Subject: Re: FW: A/31/18/OUT- notice under the Town and Country Planning (Pre-commencement Conditions) Regulations 2018

Further to your written agreement to imposition of the reptile mitigation pre-commencement condition our Engineer has stated that because the plans aren't accurate regarding the building she doesn't want to reference them. So she has suggested the following pre-commencement Drainage condition

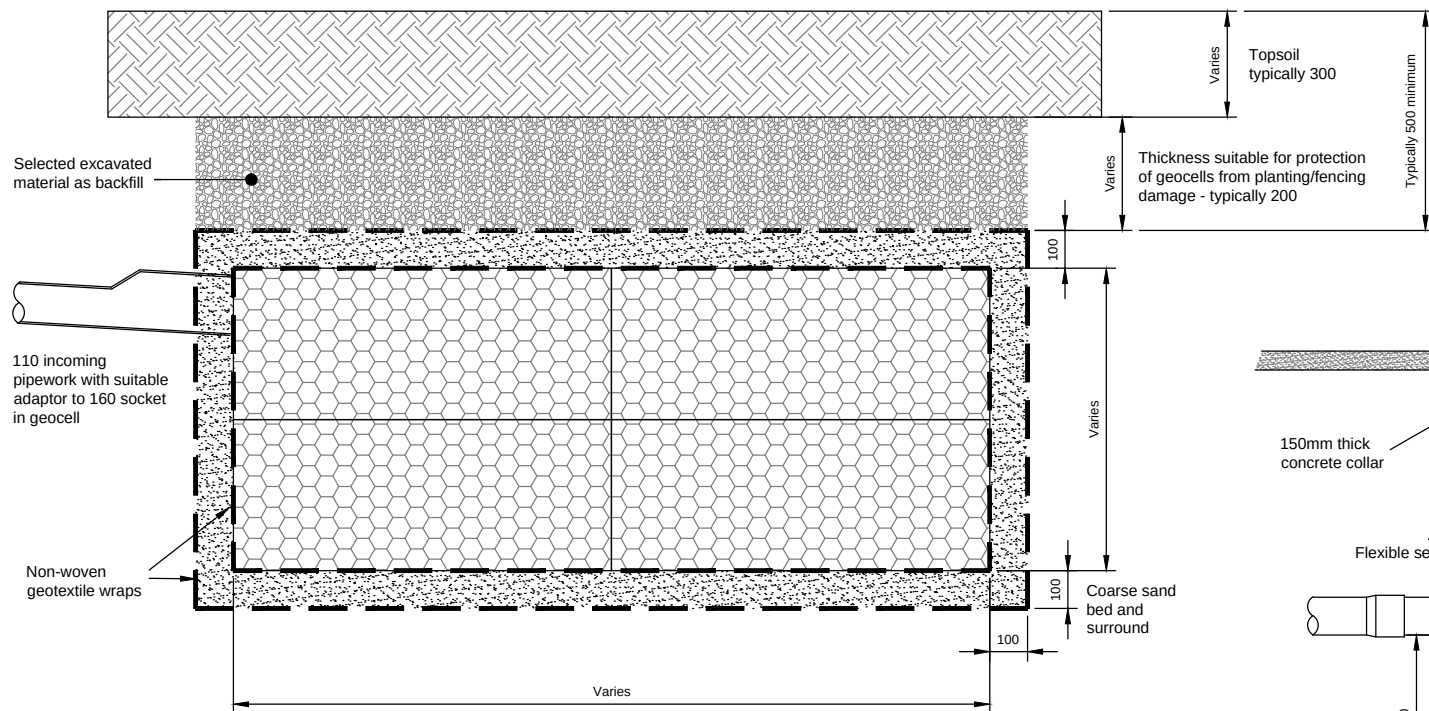
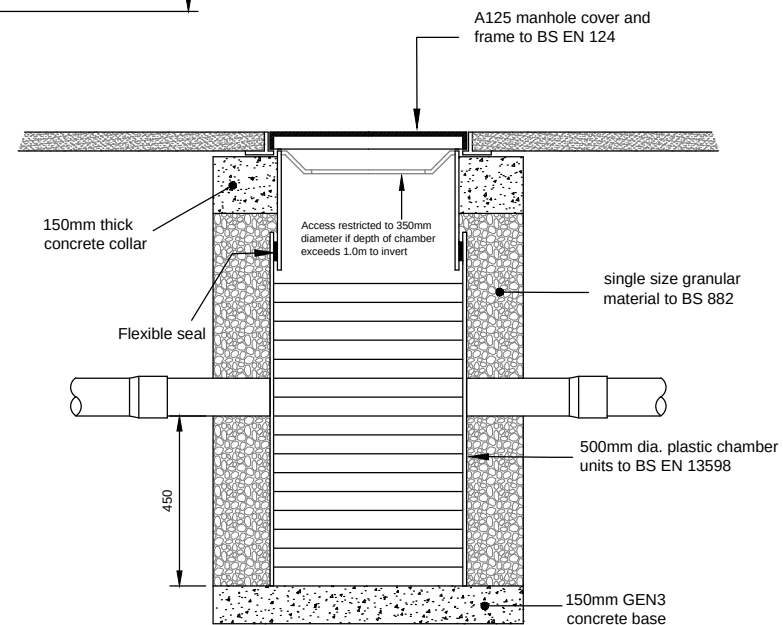
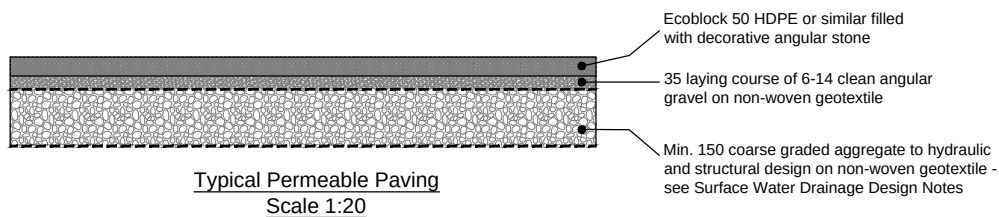
"Development shall not commence until a revised surface water drainage layout has been submitted to and approved in writing by the Local Planning Authority. The drainage design must follow the principles set out in drawing numbers 1788/SK2 and 1788/D5.1. No building shall be occupied until the complete surface water
